13 January 2023

Re: Fort Street Public School: SSD 10340, Section 4.55 Modification 2

David Burdon
Director, Conservation

Figure 4-1. Proposed floor level amendments in Building G, H and J. Source. FJMT, 17 October 2022.

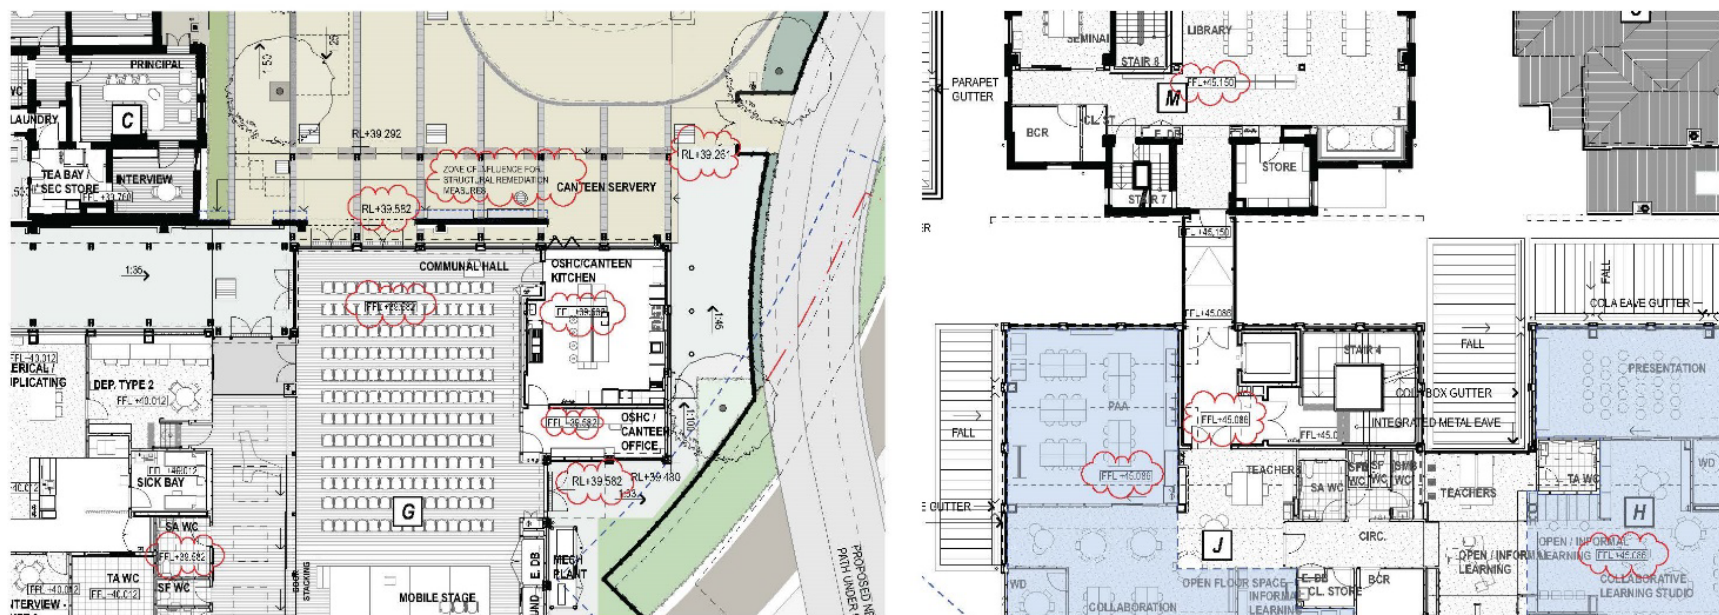
The Modification Report (p.6) claims that *“If the internal floor level amendments to Buildings F G, H and J were not proposed, then those buildings’ relationship with existing heritage fabric especially the MET Building, and surrounding finished ground levels would remain suboptimal. Moreover, the opportunity would be lost to reduce soil fill in some instances to reduce the risk of exposing the site to potential contamination risks from off-site backfill materials.”*

This raises a number of concerns. Was there previously a contamination risk from proposed backfill? Did the previous design not consider the existing floor levels of the MET building? Were the existing ground levels not properly understood? How could a project of over \$50m in value not consider such matters?

- How can a *lowering* of the floor levels of Buildings G, H, J and F by between 172mm and 260mm result in the *raising* of the overall building height by 610mm?

Figure 4-4. Proposed lift overrun amendment, Building J. Source. FJMT, 17 October 2022.

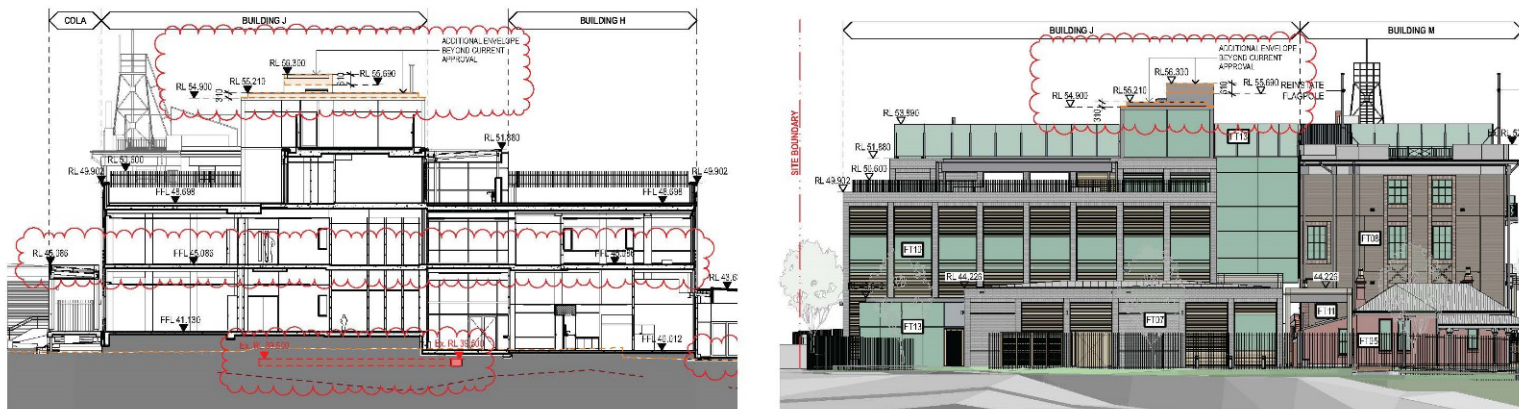
The installation of a lift has similarly been one of the major considerations in terms of access and compliance, and presumably has been subject to much design and engineering consideration. To alter this proposal at this stage to increase the building height by 610mm (not an insignificant amount) is extraordinary.

- How can a claim be made that the lift shaft cannot be lowered due to impacts on archaeology when it has previously (Mod 1) been specifically located to avoid such conflicts, and its position remains unchanged?
